CITY OF ALBUQUERQUE

RE: **Car Crafters**
5600 Holly Ave NE
Request Permanent C.O. – Not Accepted
Engineers Stamp Date 1/29/15 (C18D044)
Certification Dated: 2/1/156

Based on the Certification received 2/9/2016, the site cannot be accepted for release of Certificate of Occupancy by Hydrology until the following comments are addressed.

**CAR CRAFTERS  
GRADING AND DRAINAGE PLAN  
ALBUQUERQUE, NM  
PROJECT #14-032**

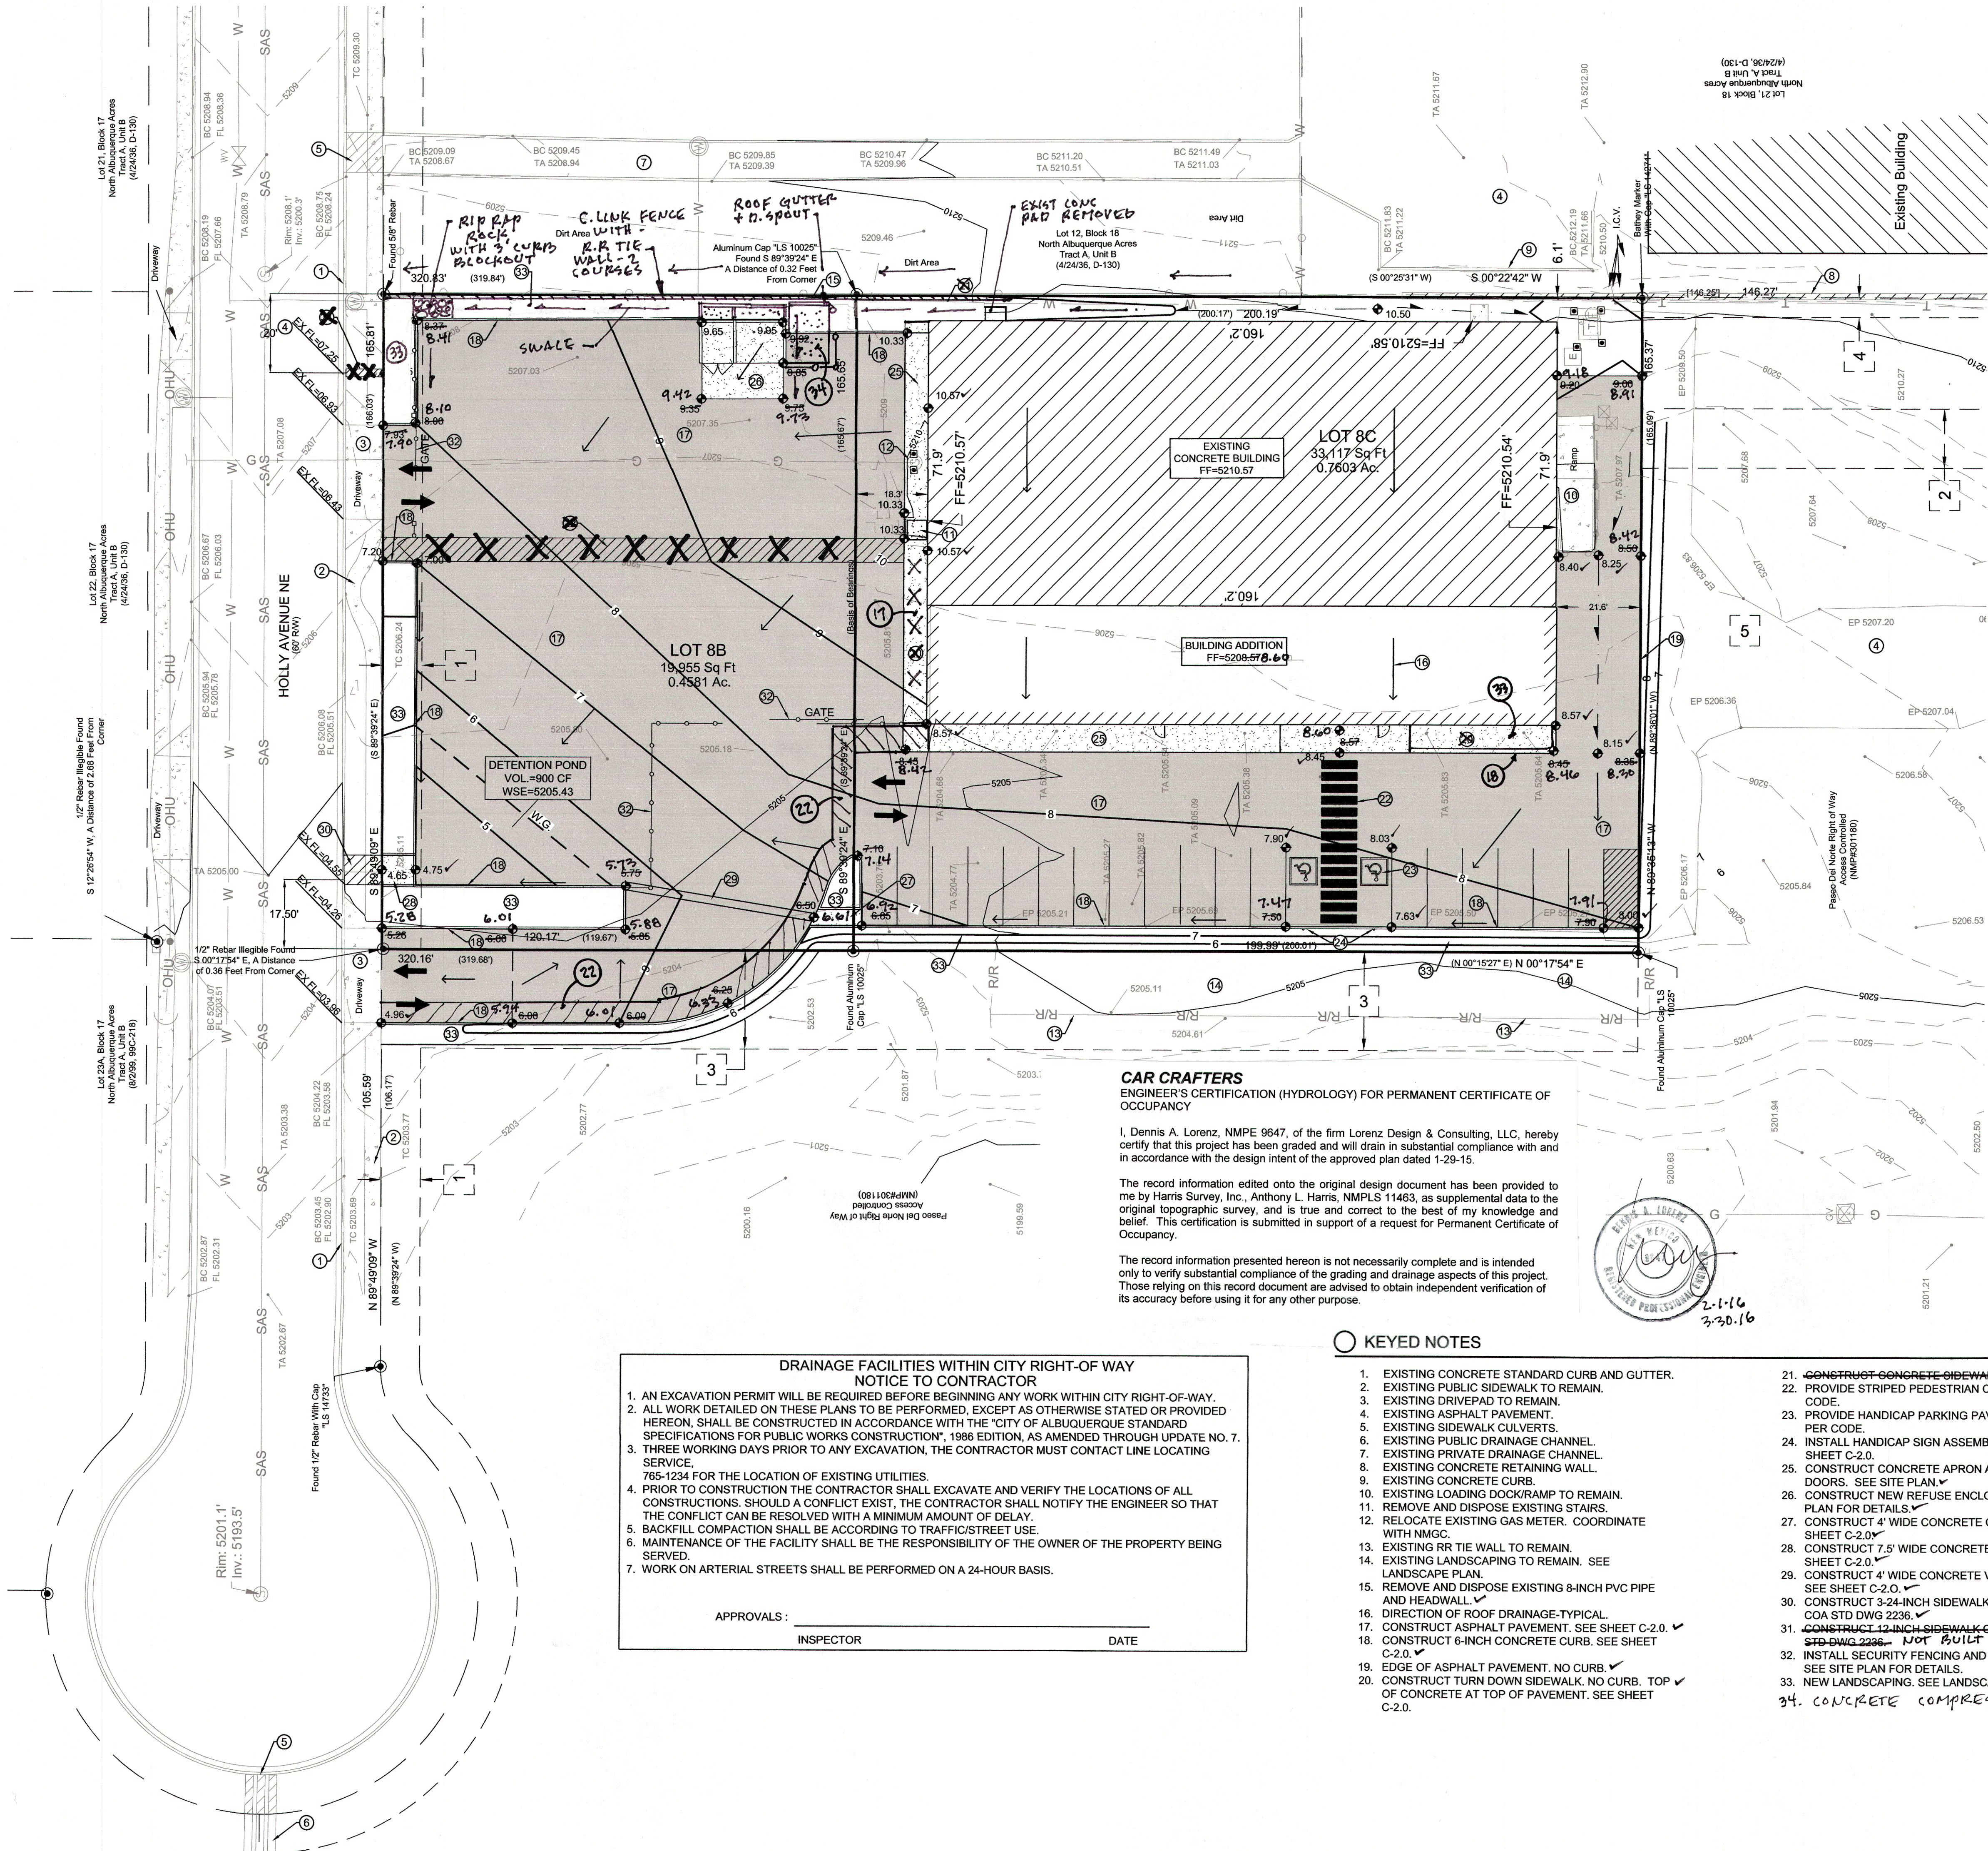
- On the east side of the building define swale to ensure that it does not discharge water to the adjacent site.
- Remove portion of stoop on east side of building so that it does not extend underneath the fence on to the adjacent site.
- Starting north of the above mention stoop, water draining north is blocked by the stoop. The swale does not exist from the stoop all the way to the NE corner and turning west at the fence corner. The swale must be defined so that water does not discharge to the adjacent site or the sidewalk north of the site. Overflow must be routed thru a sidewalk culvert.
- Provide new drainage calculations for 3'-7" channel on key note #27. The drawing calls out 4'-0".
